CITY OF ALBUQUERQUE

April 1, 2020

**Re: Kiddie Academy Westside
Paradise/Nunzio
Traffic Circulation Layout
Architect's Stamp 03-31-2020 (C12-D003A)**

11 H.C SIGNAGE  
NTS

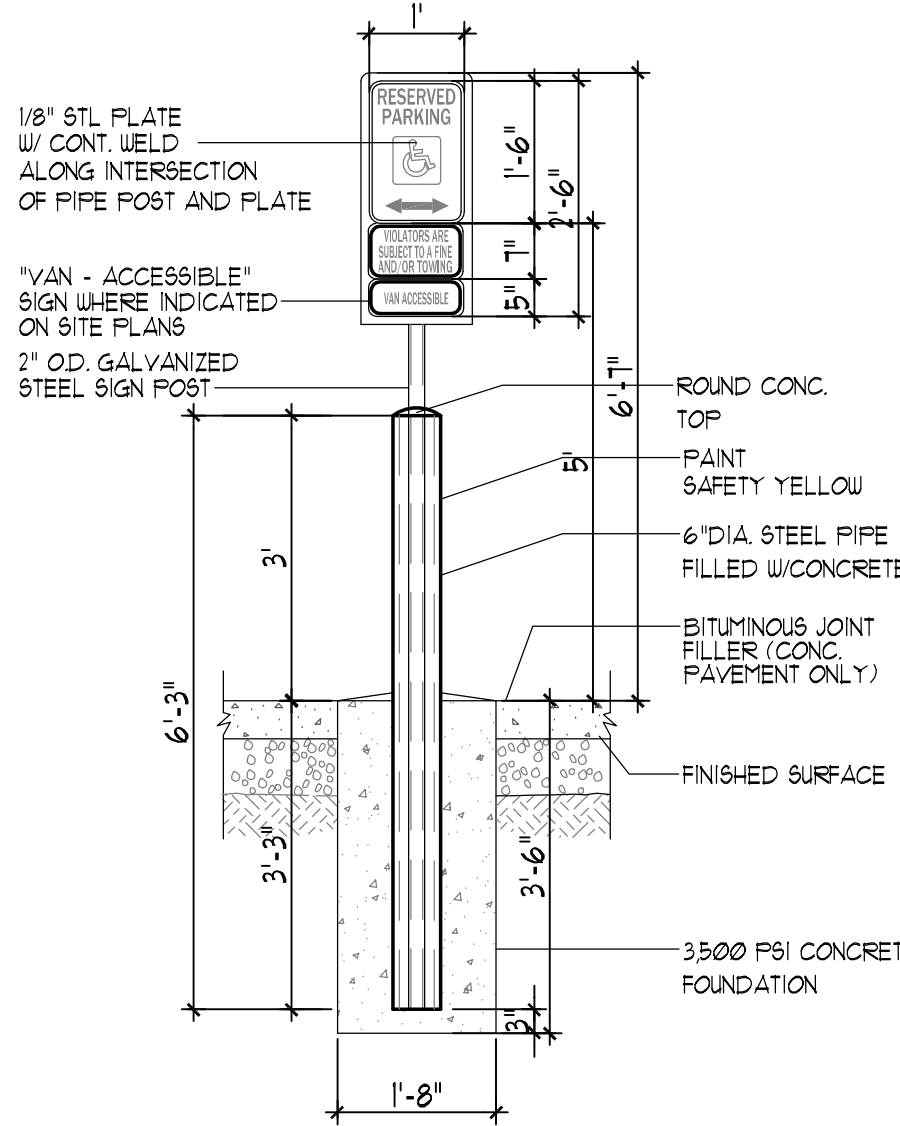
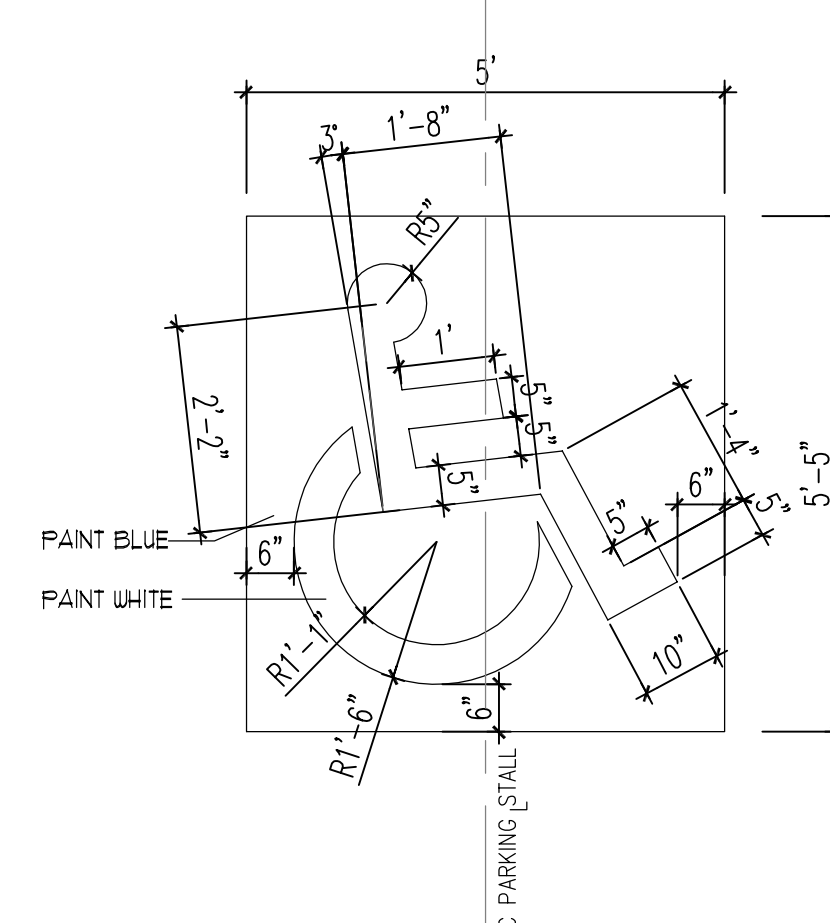
8. The ADA accessible parking sign must have the required language per 66-7-352.4C NMSA 1978 **"Violators Are Subject to a Fine and/or Towing."** Please call out detail and location of signs.
